PORTLAND MAINE

November 7, 2008

CBL: 013 E018001
Located at 34 WASHINGTON AVE

STOP WORK ORDER

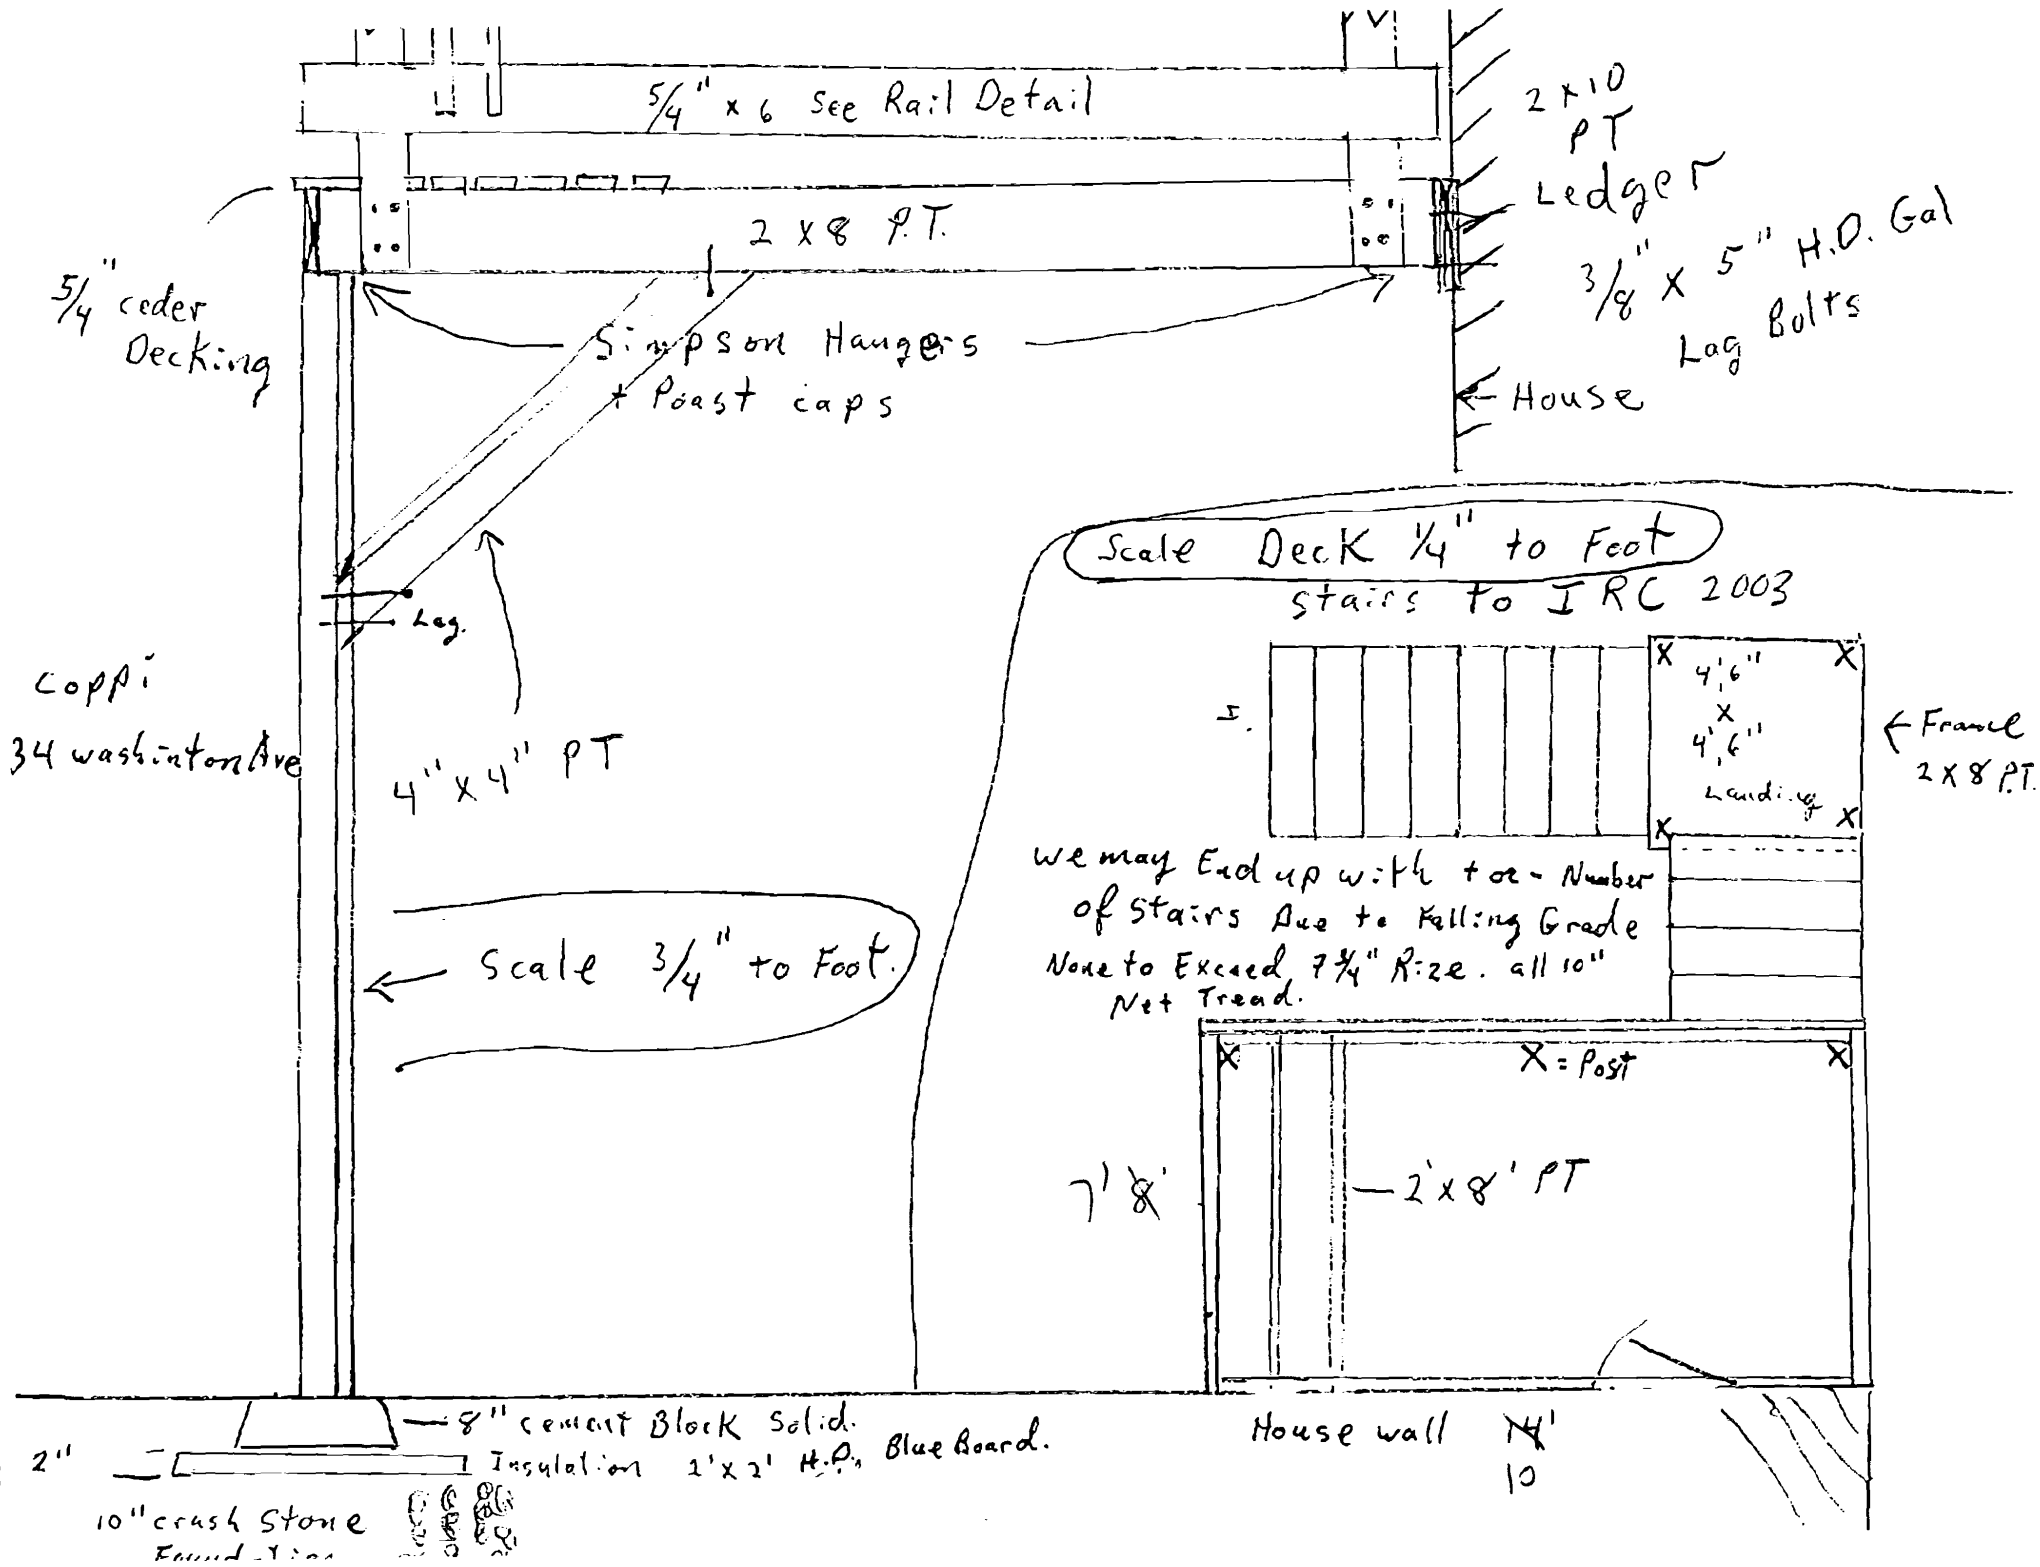
This letter is being sent as a follow up to the inspection of the above referenced property on October 31, 2008. As the property owner, you are being apprised of the action taken on building permit # 07-0813. The applicants, Sarah and Chris Coppi, deviated from the approved permit in the location of the stairs attached to the 2nd floor exterior deck. This deviation has resulted in the non-conformance of the stairs as to the required side setback.

The construction activity can resume only after issuance of the appropriate amendment to building permit #07-0813, and the subsequent lifting of this order. We understand that the abutting property owner may pursue a change of use for a retail space in the first floor. This could effect the setback requirements of the stairs; however there is no record of such application at this time. Regardless, an amendment for changes in the approved permit would be required; the non-compliant stairs shall be removed or located as drawn in the approved permit.
